Appeal Decision

Appeal Ref: APP/R5510/X/23/3314443

44 Mount Pleasant, Ruislip, Hillingdon HA4 9HG

- The appeal is made under section 195 of the Town and Country Planning Act 1990 as amended against a refusal to grant a certificate of lawful use or development (LDC).
- The appeal is made by Alan Rock against the decision of the Council of the London Borough of Hillingdon.
- The application ref 46943/APP/2022/3062, dated 6 October 2022, was refused by notice dated 1 December 2022.
- The application was made under section 192(1)(b) of the Town and Country Planning Act 1990 as amended.
- The development for which a certificate of lawful use or development is sought is the conversion of roof space to habitable use to include a rear dormer, 2 front rooflights and conversion of roof from hip to gable.

Drawing Title	Date: 19.08.2022
Proposed Side Elevations	
Scale 1:100	A3
Drawn By: DP	Checked By: ZA
Approved By: AR	Revisions 01
Drawing No. SB22/AR/011

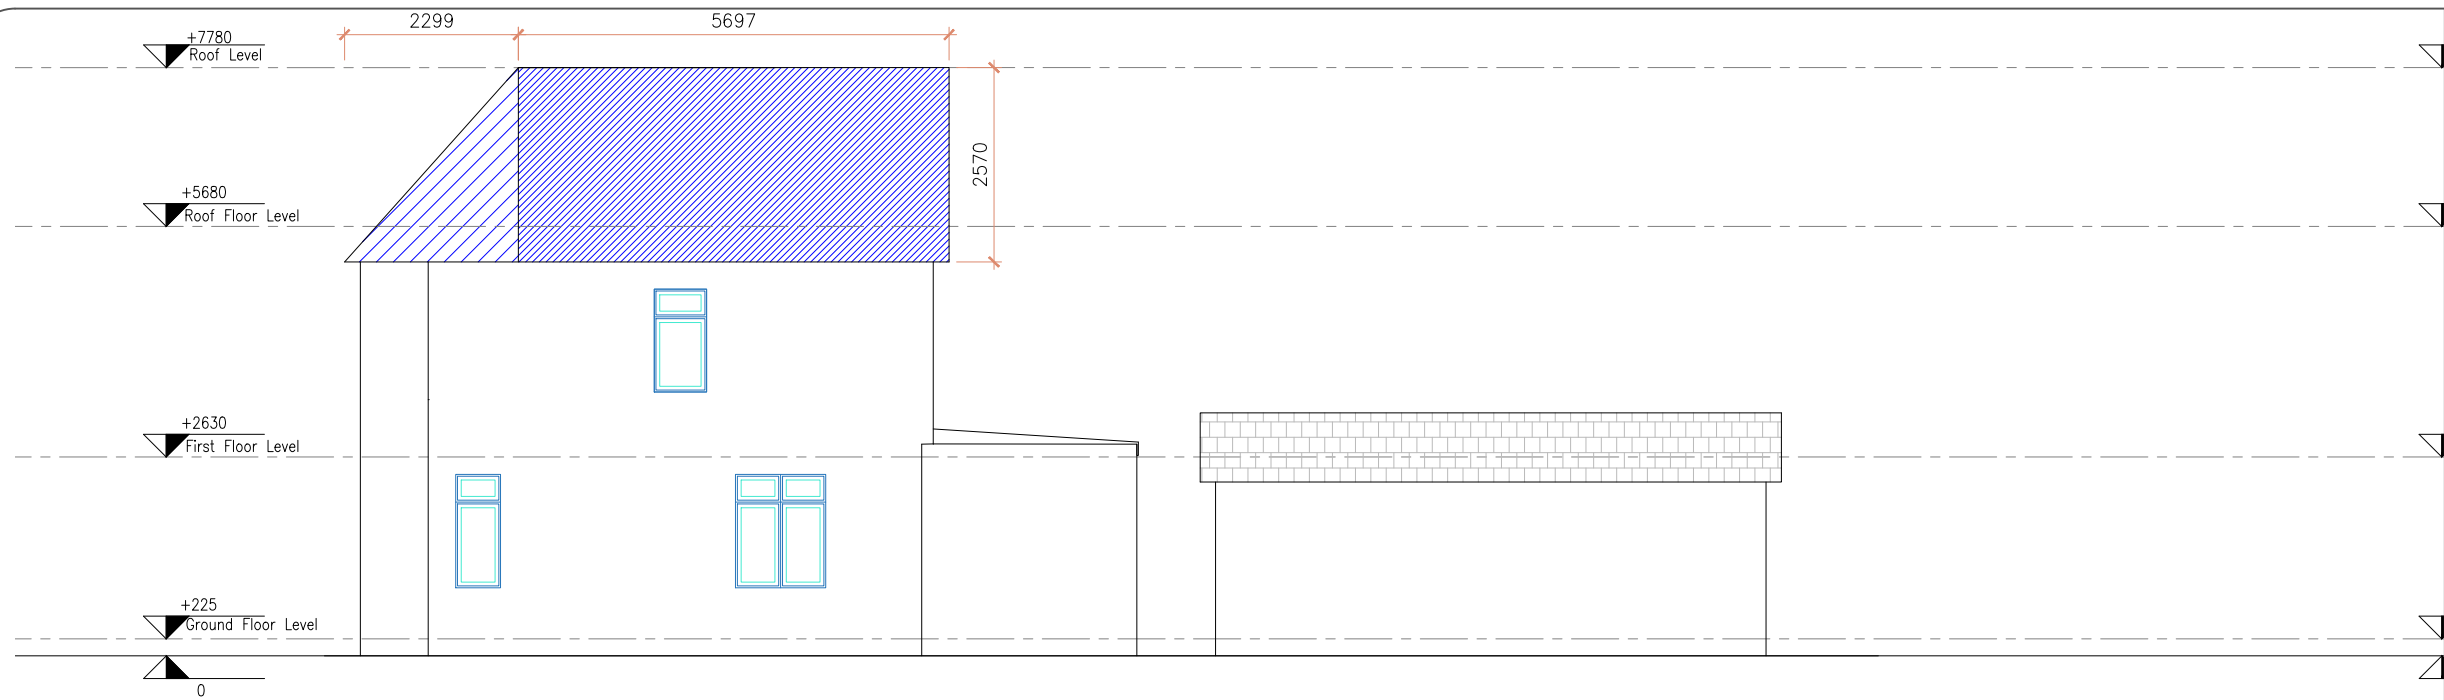
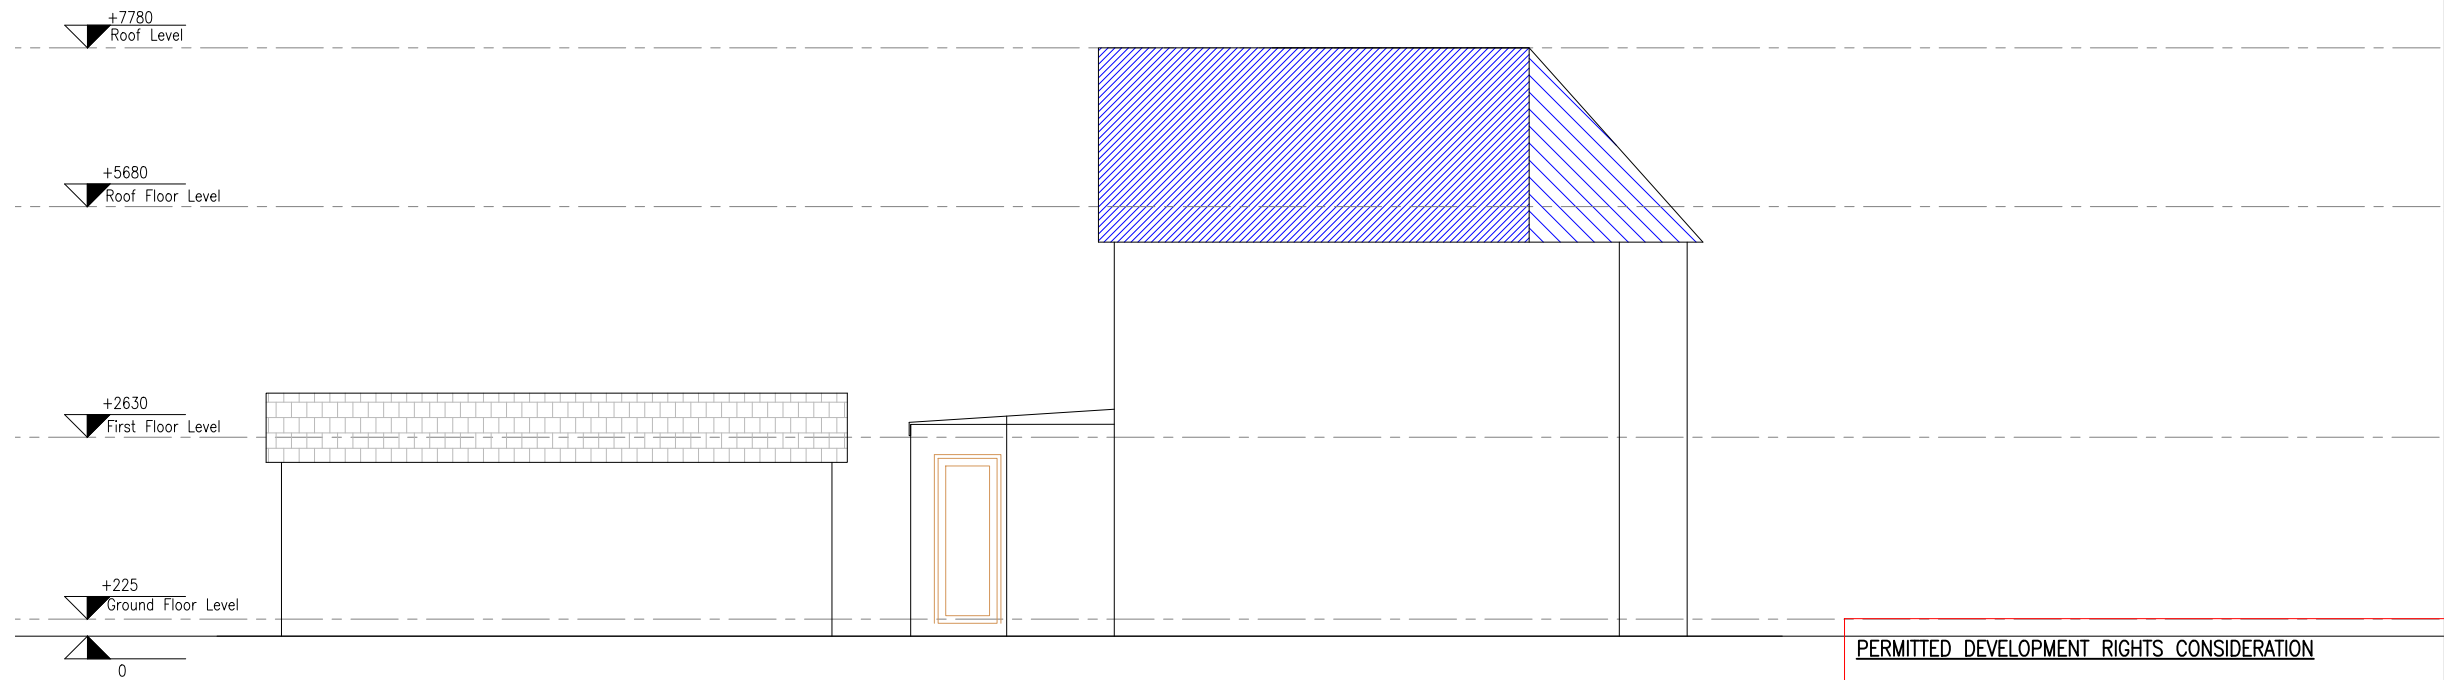
8. With the above in mind, the proposed works would significantly alter the shape, form and design of the roof structure as well as changing the orientation of the ridgeline. In this regard, and based on the evidence submitted with the appeal, carrying out the proposed works as a single building operation would no doubt lead to little, if anything, of the existing roof structure remaining. I therefore concur with the Council and conclude that the works would amount to a new roof structure rather than an enlargement of the existing roof. In this respect, the provision of a new roof goes beyond what would be permitted by Classes B and C, as they only permit the enlargement of a dwellinghouse consisting of an addition or alteration to its roof.

17 PROPOSED REAR ELEVATION

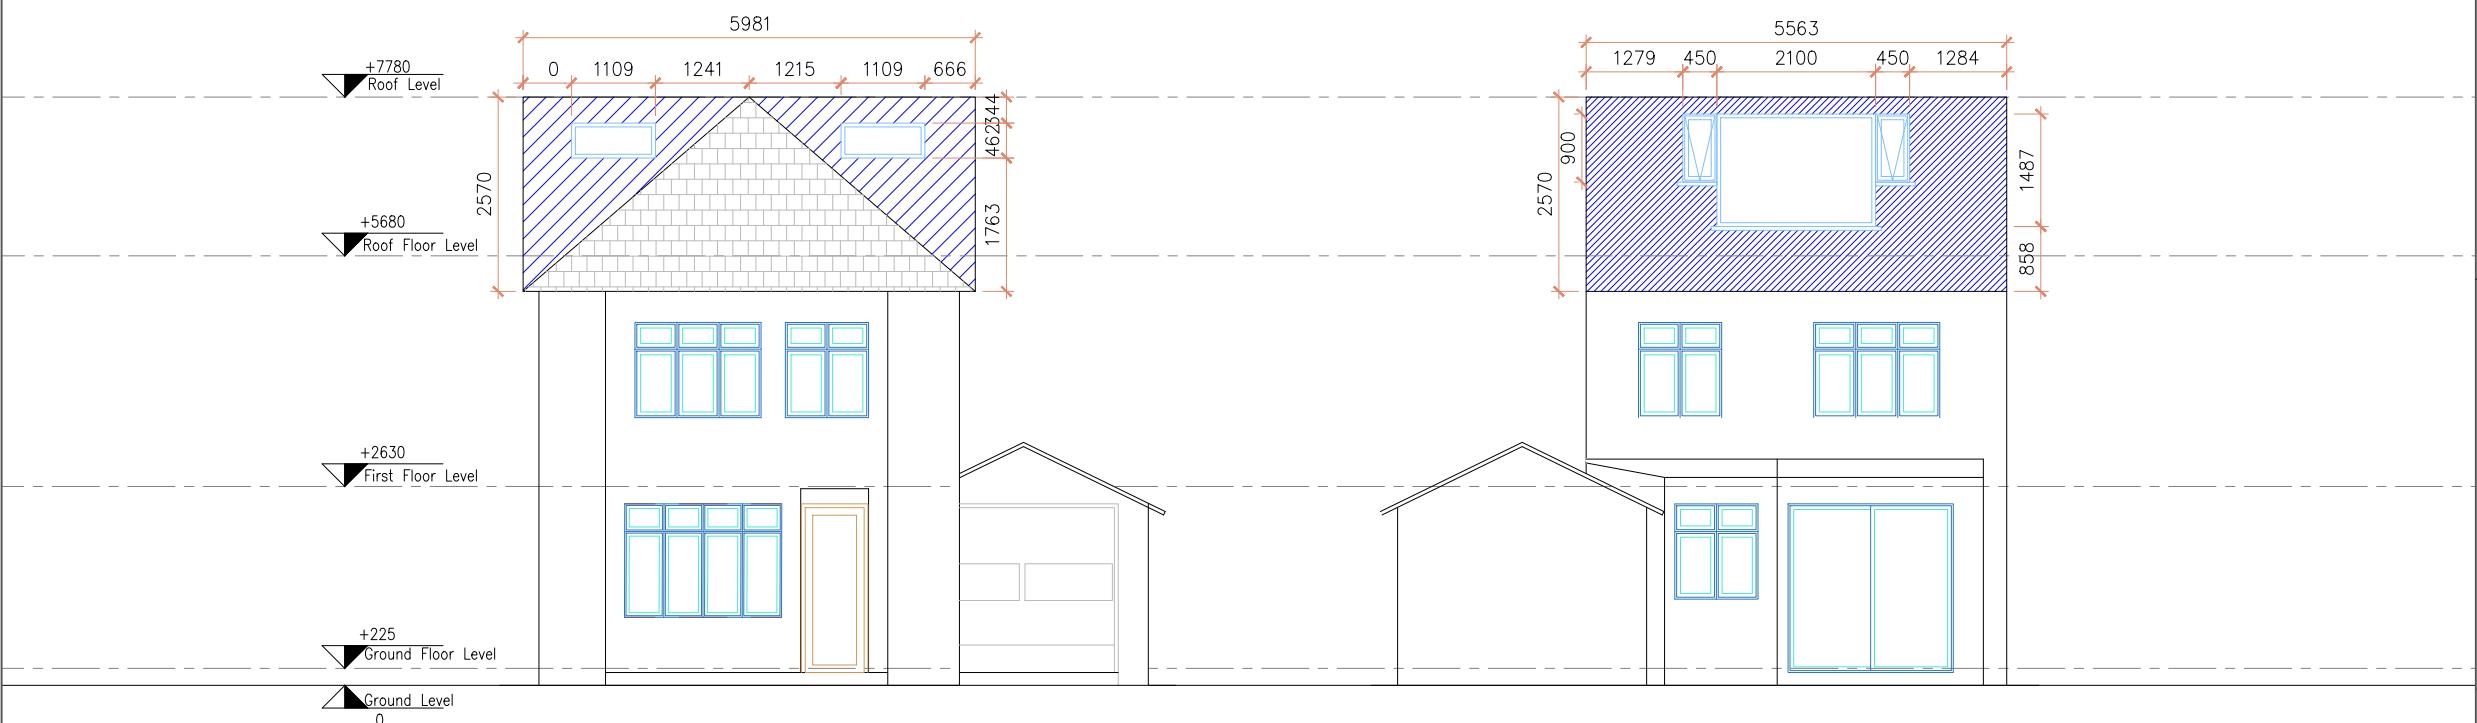
10. It is recognised that the proposed development involves a hip to gable loft conversion, but it also proposes a rear dormer. As such, although the hip to gable element could be compliant with the above, the rear dormer would be contrary to these conditions. In particular, the rear elevation of the dwellinghouse would be extended to form the rear dormer, completely removing the rear section of the existing roof and its eaves. As such, the eaves at the rear of the original roof would not be maintained or reinstated. For similar reasons, the loss of the original eaves means there would be no rear roof slope, therefore, the dormer would not be more than 0.2m from the eaves.

11. Condition B.2 (ii) also states that 'other than in the case of an enlargement which joins the original roof to the roof of a rear or side extension, no part of the enlargement should extend beyond the outside face of any external wall of the original dwellinghouse.' Based on the plans submitted with the appeal, this is not a case where the enlargement joins the original roof to the roof of a rear or side extension. Further to this, the plans show the rear dormer extending beyond the face of the rear external wall of the original house.
